I am writing to formally oppose the variance of use request for 11910 Green Acres Lane, submitted by Sterling Providence LLC / Joseph Z Ministries / et al. As a neighboring resident who shares a property line with 11910 and is directly impacted by the activities at this site, I respectfully ask the Board to evaluate this application with careful attention to the criteria outlined in Section 5.3.4(C) of the El Paso County Land Development Code.

Sincerely,
Jason Roberts
11750 Green Acres Lane

**SITE PLAN**

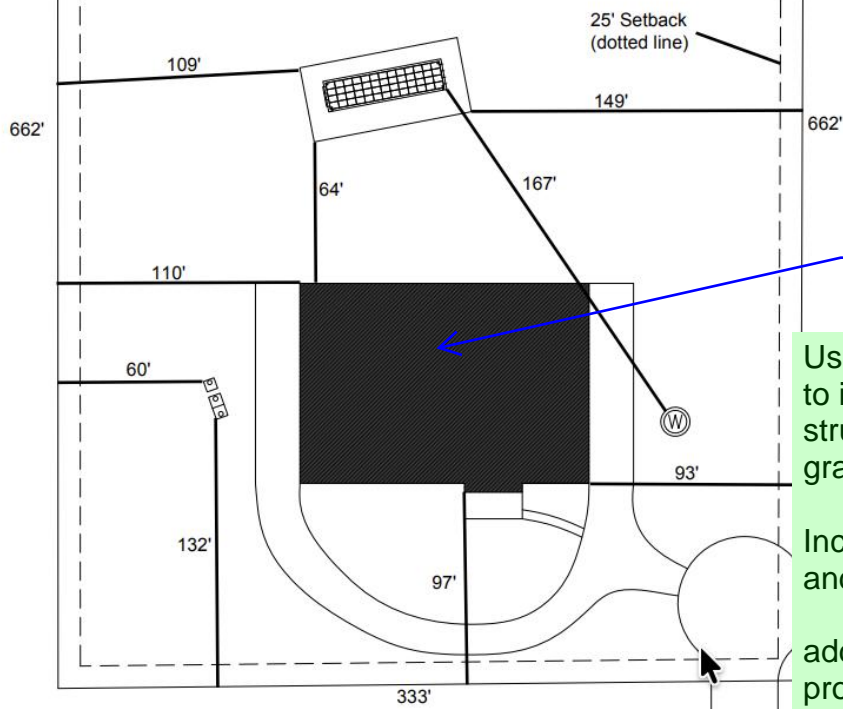
In addition, the presence of multiple large shipping containers on the property does not appear to have been fully accounted for in the reported disturbed land areas, and the landscape plan appears to misrepresent existing tree coverage on the site. Taken together, these discrepancies among many others suggest that the true scale and impact of the operation have been materially understated and make it difficult to rely on the application as an accurate representation of the proposed use.
